17 March 2019

## **SUBMISSION FOR STAGED REDEVELOPMENT OF GREENWICH HOSPITAL SSD 17\_8699**

MARK-UP OF S04/T3 TO SHOW ERRORS/OMISSIONS

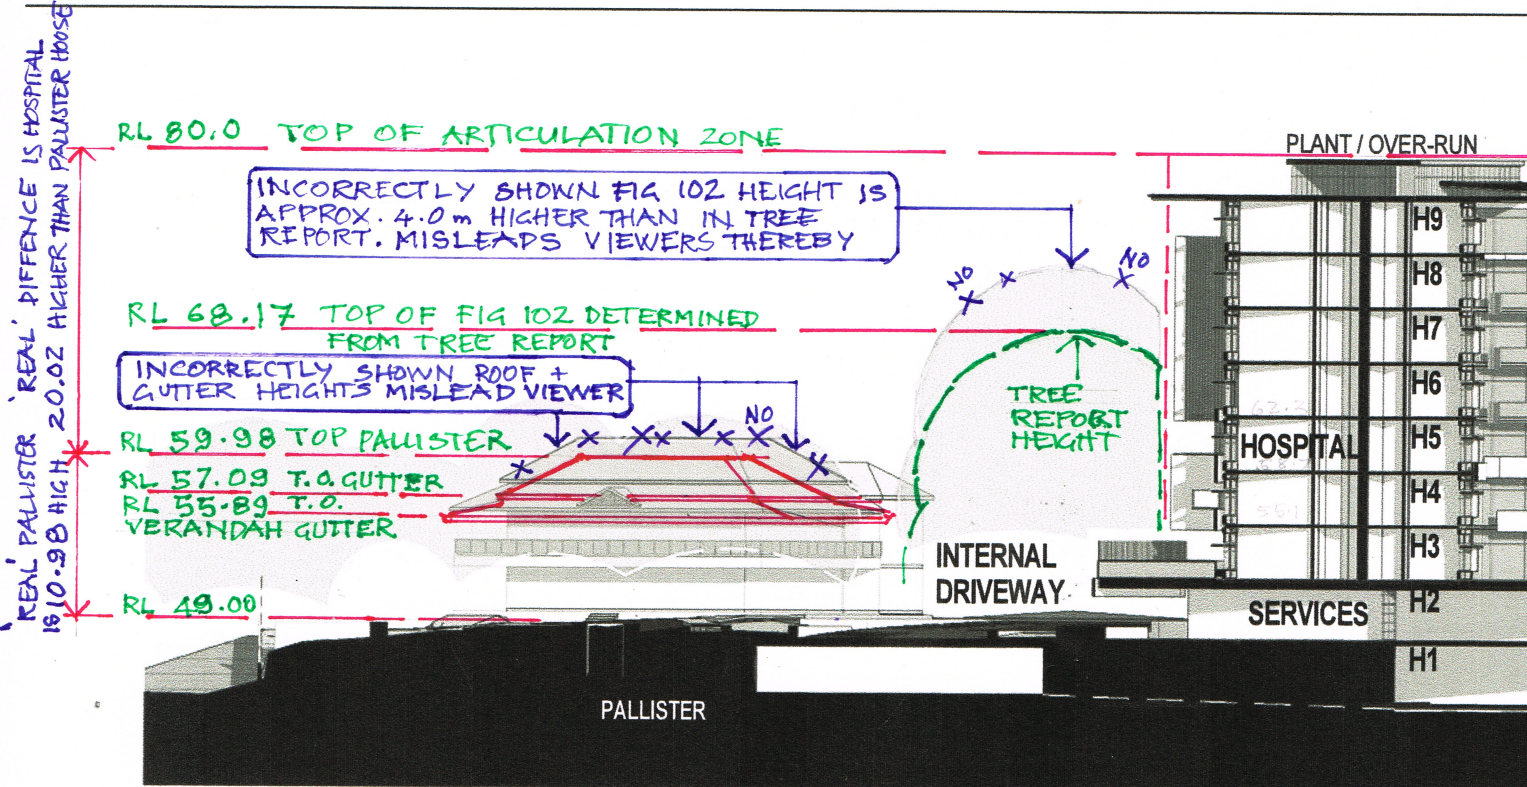
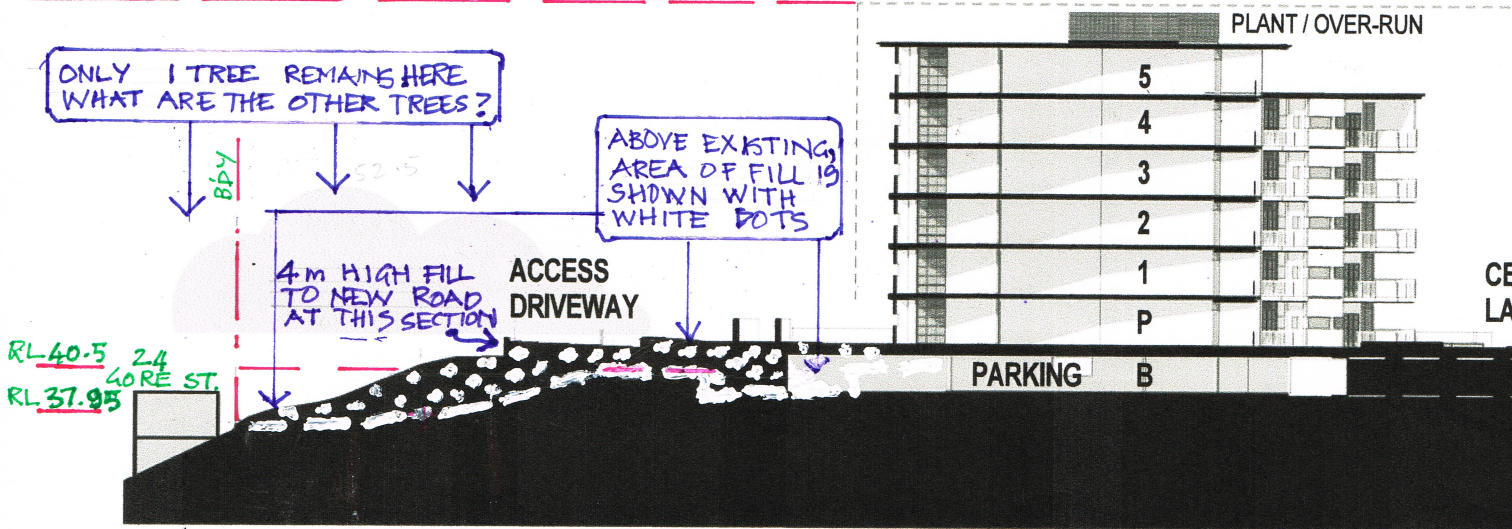
The bulk and scale is not in keeping with the residential nature of development along River Road. The building height information indicated on the architectural plans and in the Statement of Environmental Effects (SEE) is unhelpful, as ground level RLs are not clearly indicated. This means that, although top of building levels are shown, it is not easy to appreciate how high these buildings are from adjacent ground levels. The Senior Living Apartments appear to be between 15 and 20 m high, but are set back only 5 m from River Road. The main hospital is at least 30m high, which is significant for an area where the general building height is less than 8m. As a result, the statement in Part 10.1 of the SEE that the development protects and enhances the amenity of the area seems far-fetched.

- be designed so that no building is constructed in a riparian zone. This proposal **does not appear to comply** as Seniors Living Apartments appear to be located within, or very close to, the riparian zone indicated on the Lane Cove Council Local Environmental Plan 2009 Riparian Land Map. Further clarification of the location of buildings in relation to the riparian zone outline should be provided.
